**Monday, November 1, 2021**

**Mercer Island  
Permit No. 2108-113**

**MERCER ISLAND  
Response to Second Intake  
Screening**

**Fire Marshal Jeromy Hicks**  
[Jeromy.hicks@mercerisland.gov](mailto:Jeromy.hicks@mercerisland.gov)  
206-275-7966

A2

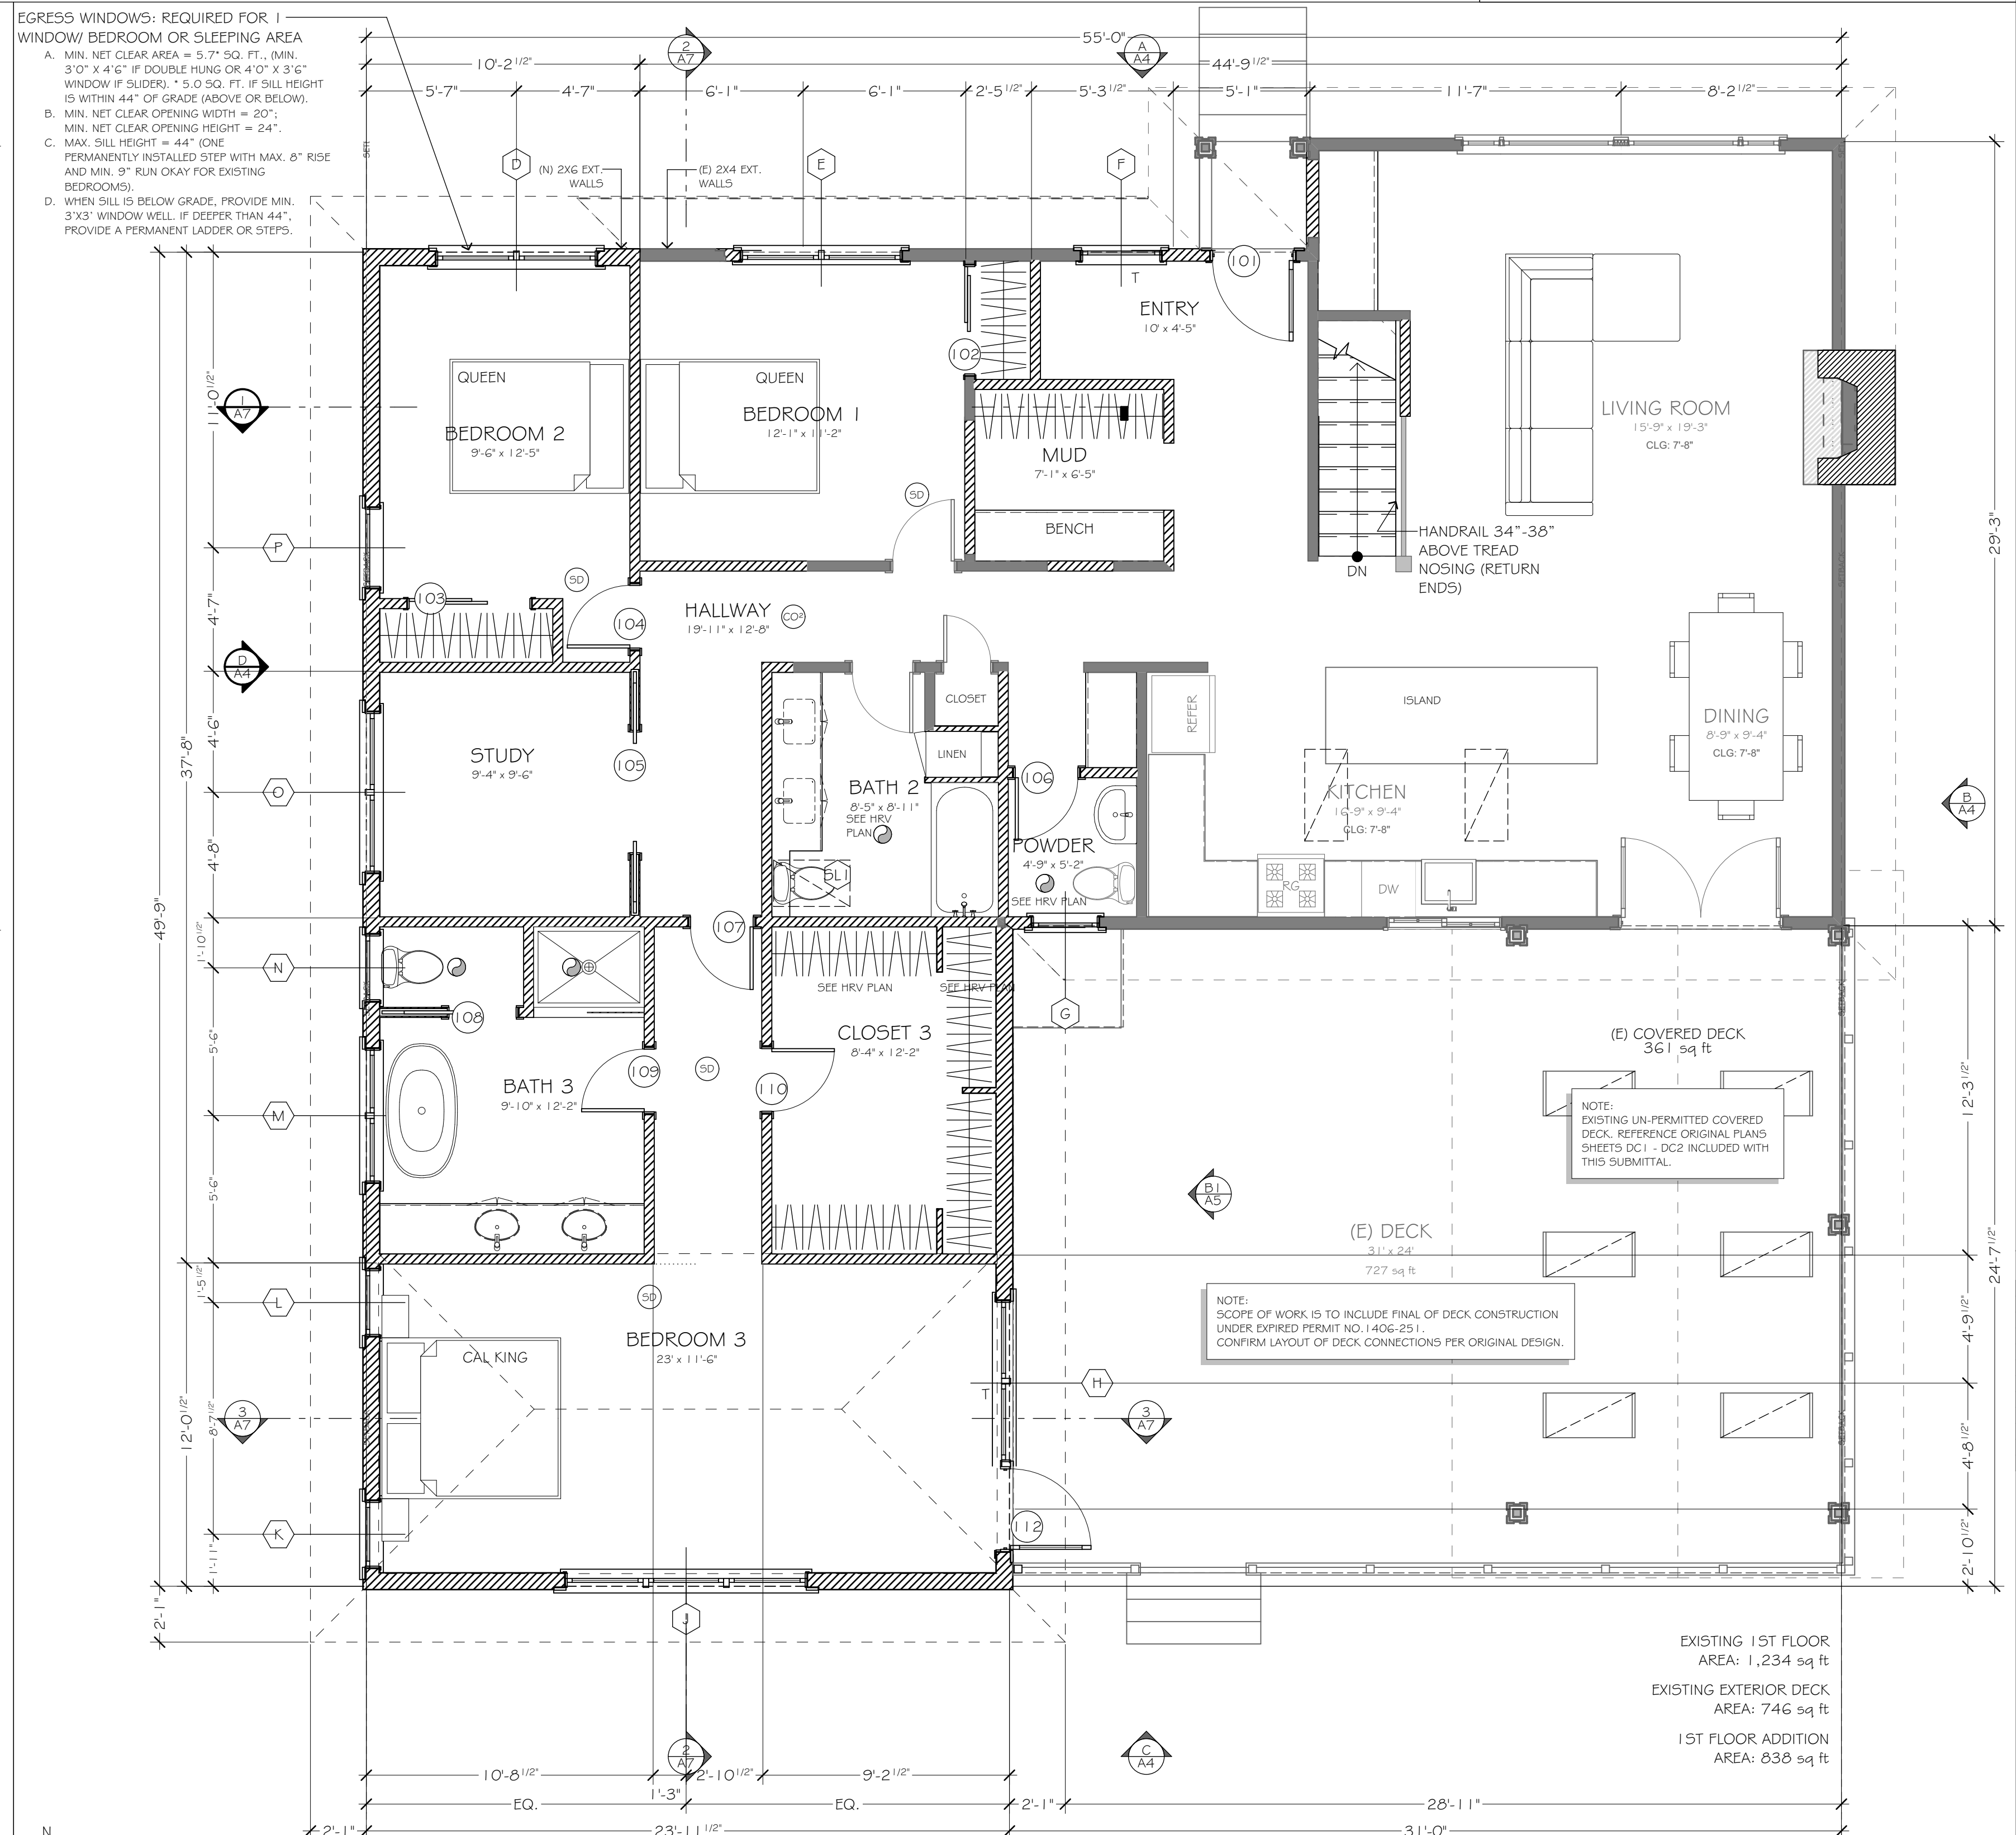
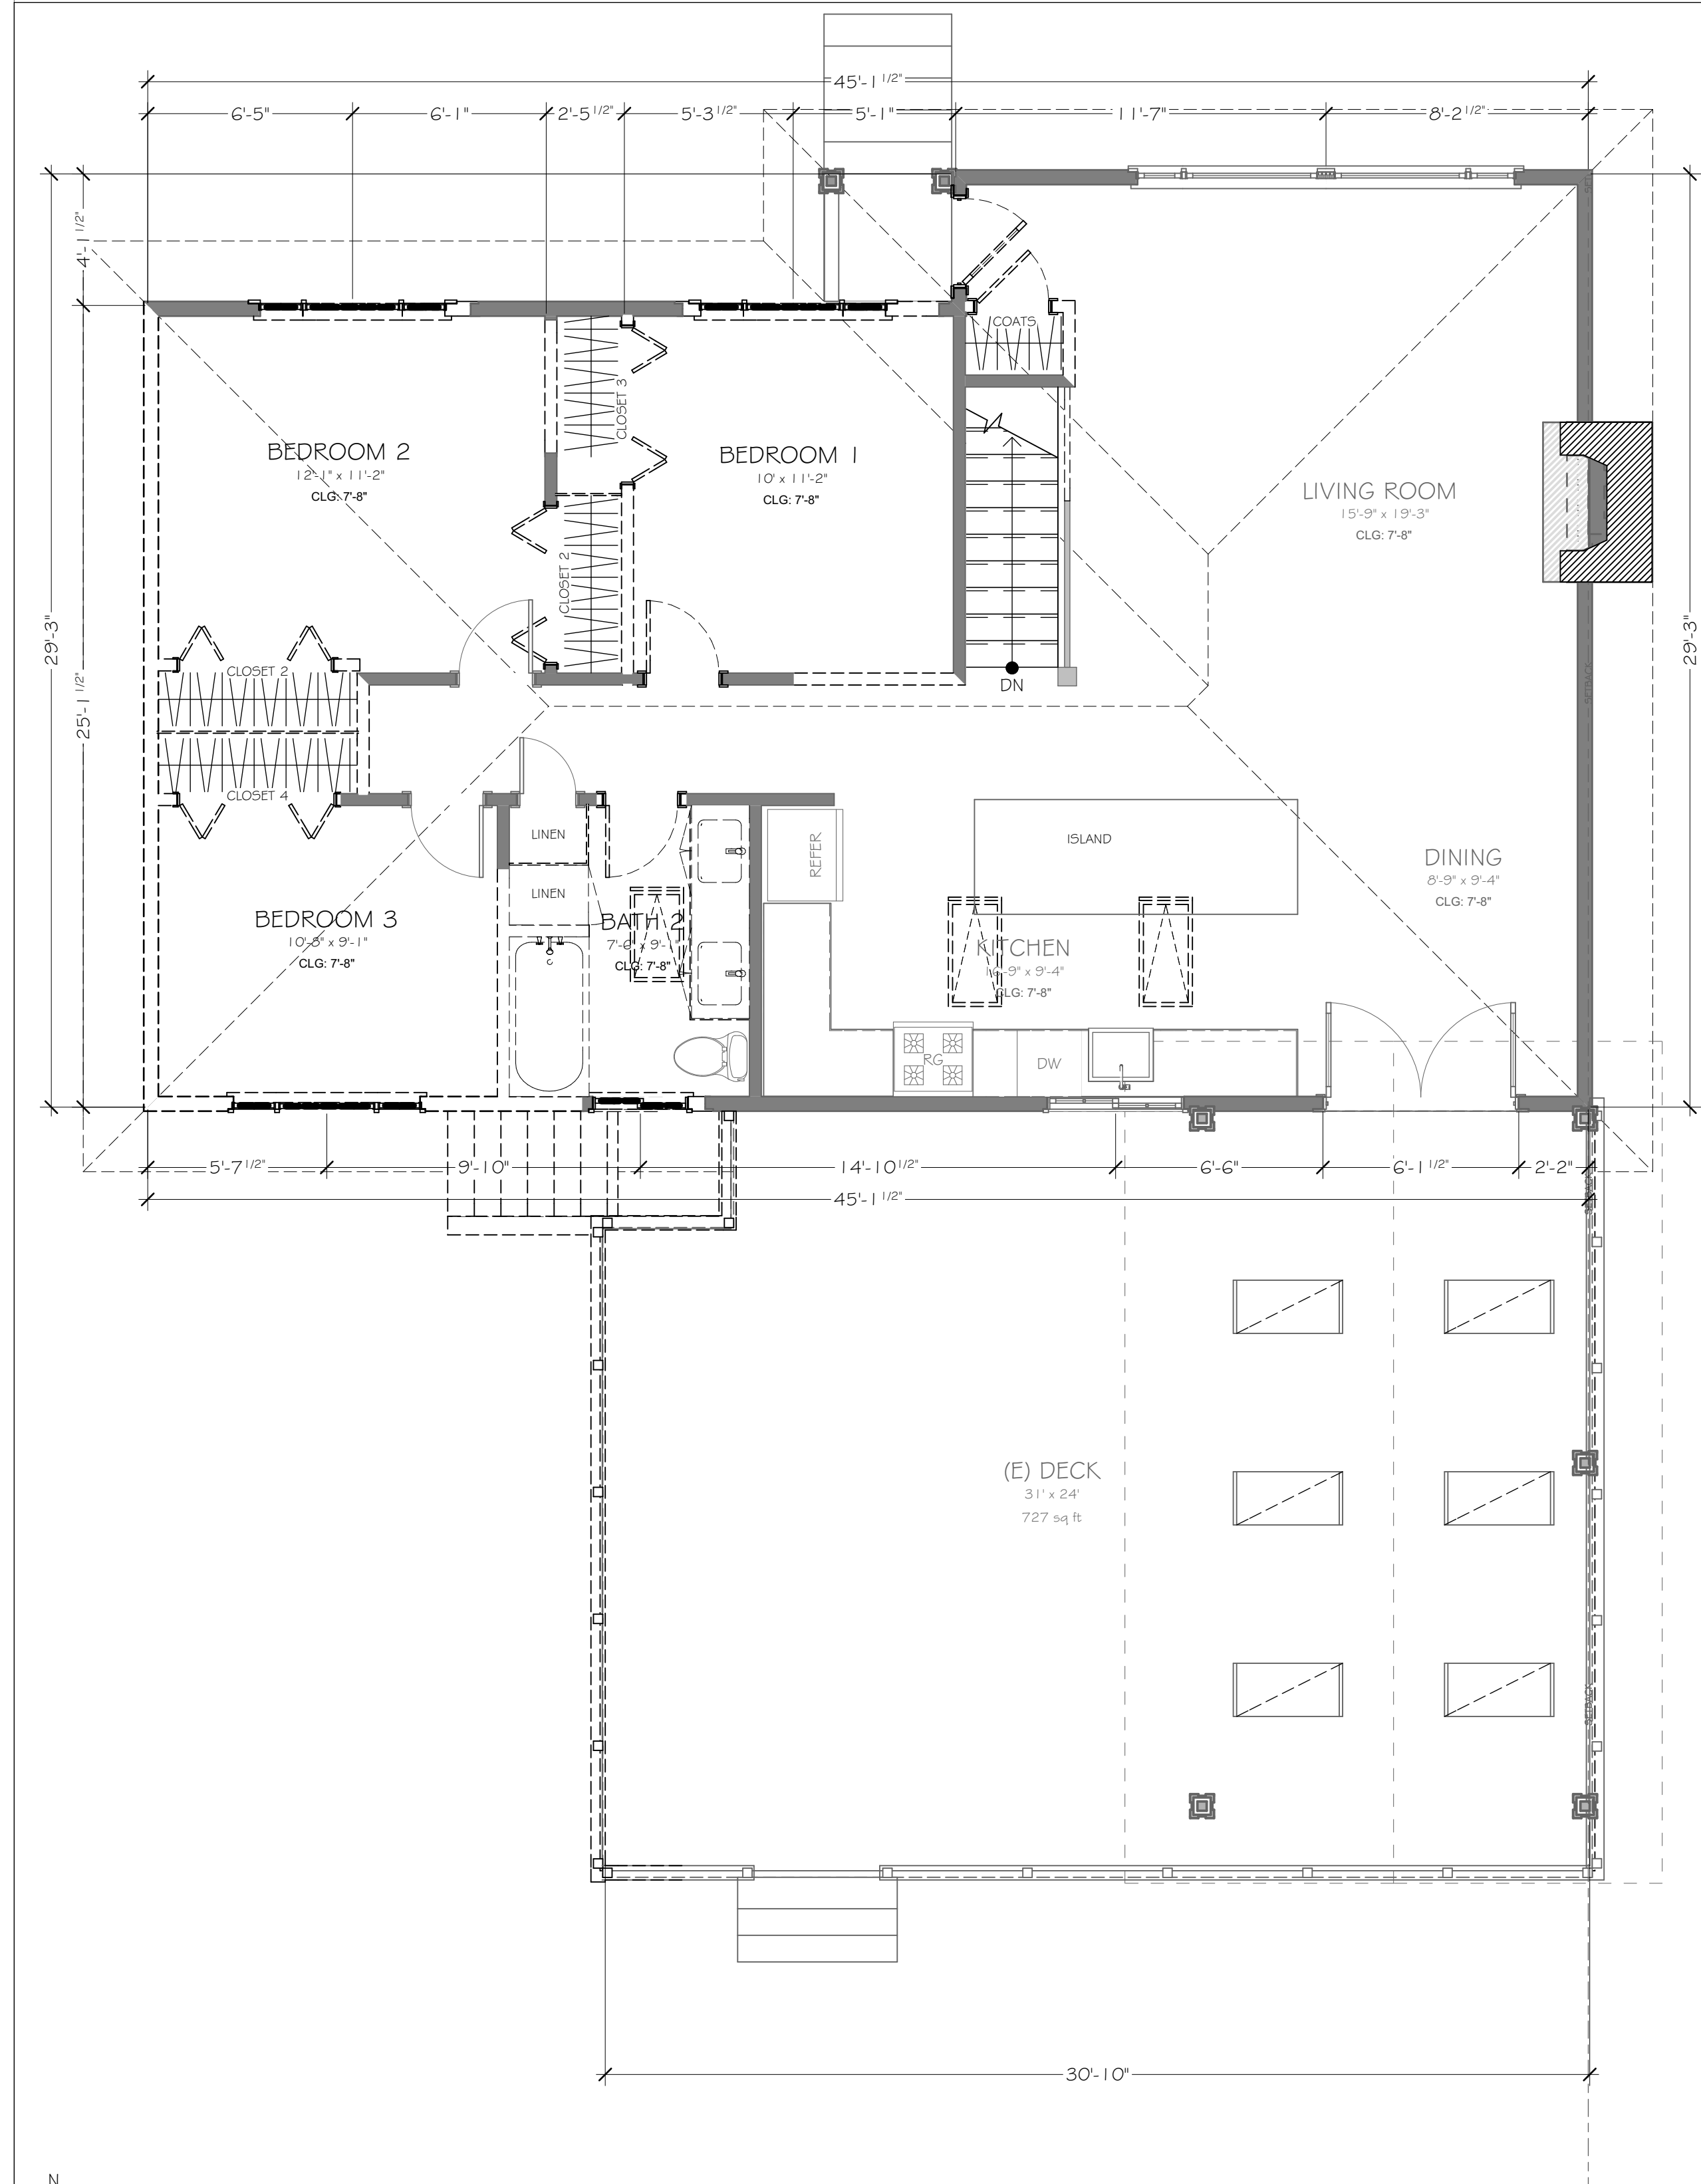
**Confirm that 13d will be installed. This will require a separate permit and may be deferred. Please indicate this on the plan set.**

**Smoke detectors and/or sounders must activate upon waterflow of the fire sprinkler system. Please indicate this on the plan set.**

*RESPONSE: Fire sprinkler system notes added to sheet A1, A2.*

*RESPONSE: Fire sprinkler system notes added to sheet A1, A2.*
